Our Ref: STH20/00163/03

SSD-9409987, MOSS VALE PLASTICS RECYCLING FACILITY, ENVIRONMENTAL IMPACT STUDY (EIS) – PUBLIC AGENCY CONSULTATION

TfNSW has completed a review of the information provided, including the Traffic and Transport Assessment (report with Project No. 12524108, Moss Vale Plastics Recycling and Reprocessing Facility - Technical Report 6 – Traffic and Transport, Revision 2 dated 27 January 2022 prepared by GHD) while focusing on the impact to the state road network.

Figure 6.6 Proposed Haulage routes to and from the of the site (19m GML and CML vehicles)

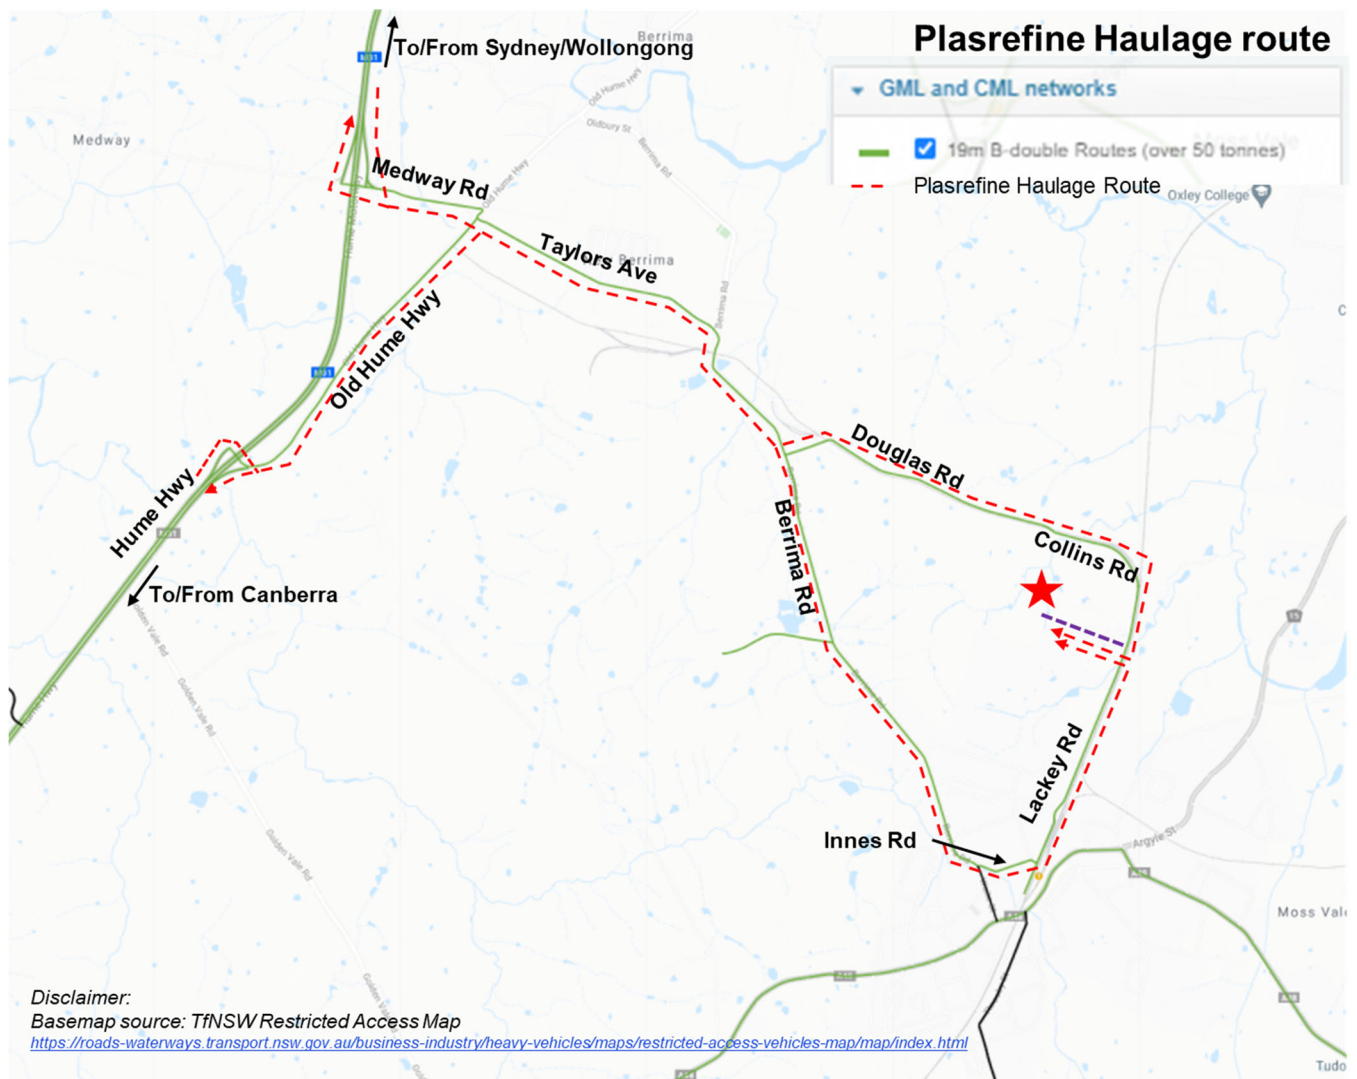
Figure 6.6 Proposed Haulage routes to and from the of the site (19m GML and CML vehicles)

1. Rail Crossing

TfNSW notes the traffic assessment states that 40% of vehicle movements will be from the north with the proposed haulage route indicating that the trucks that will be delivering and exporting plastics will come from the west (refer to Attachment 2). As such, the proposal will increase the number of vehicles that cross the at grade rail crossing that is located to the north of the development site (refer to Attachment 1).

TfNSW understands that this rail line is a Boral Branch line and is not controlled/managed by the Australian Rail Track Corporation (ARTC). It is however noted that there is limited infrastructure currently provided at this at grade crossing and given the increase in vehicle movements there may be a need to activate the crossing. In this regard, it is suggested that an Australian Level Crossing Assessment Model (ALCAM) be undertaken to identify potential risks and any required upgrades.
